Please ask for: Mrs D Johnson
Email: daun.johnson@arun.gov.uk
Telephone: 01903 737762
Our Ref: WA/79/20/PL
Your Ref:
Date: 27th October 2020

Application for Planning Permission

Development: Demolition of existing dwelling & erections of 8 No. new dwellinghouses with associated landscaping & parking (resubmission following WA/30/20/PL). This application is a Departure from the Development Plan & is in CIL Zone 3 and is CIL Liable.

Location: Spindlewood Yapton Lane Walberton BN18 0AS

Second Floor Plan 1:100 @ A3

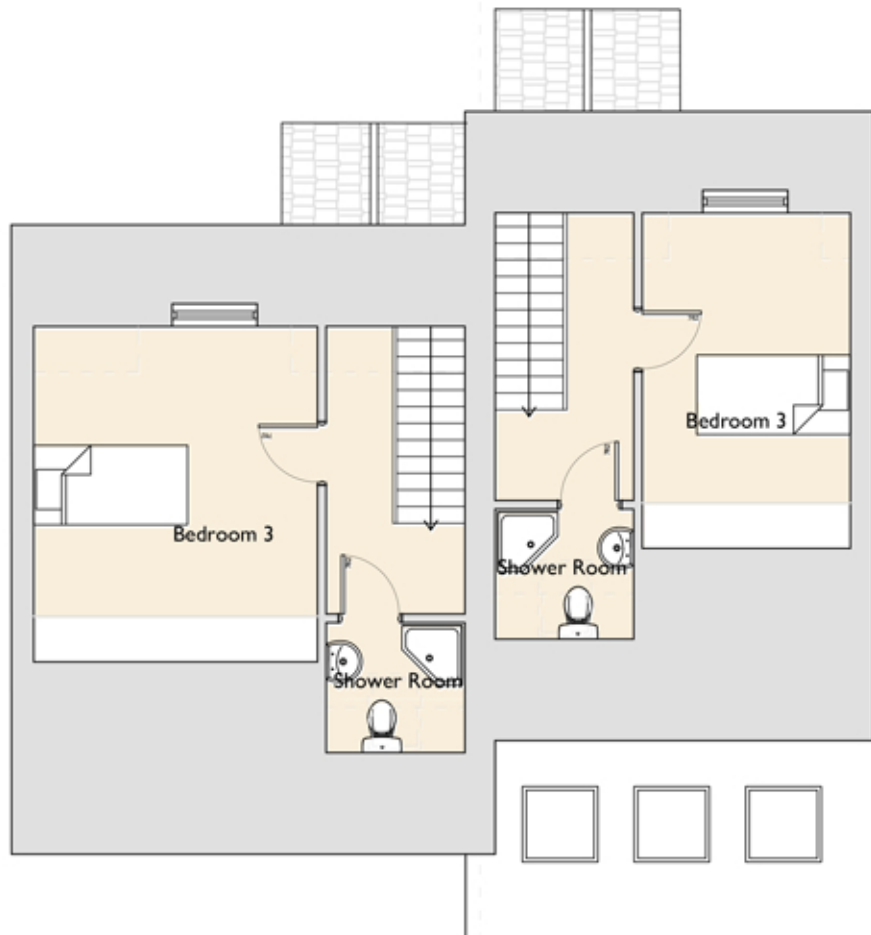
Please show the roof lights on the second floor plan for the cottages.
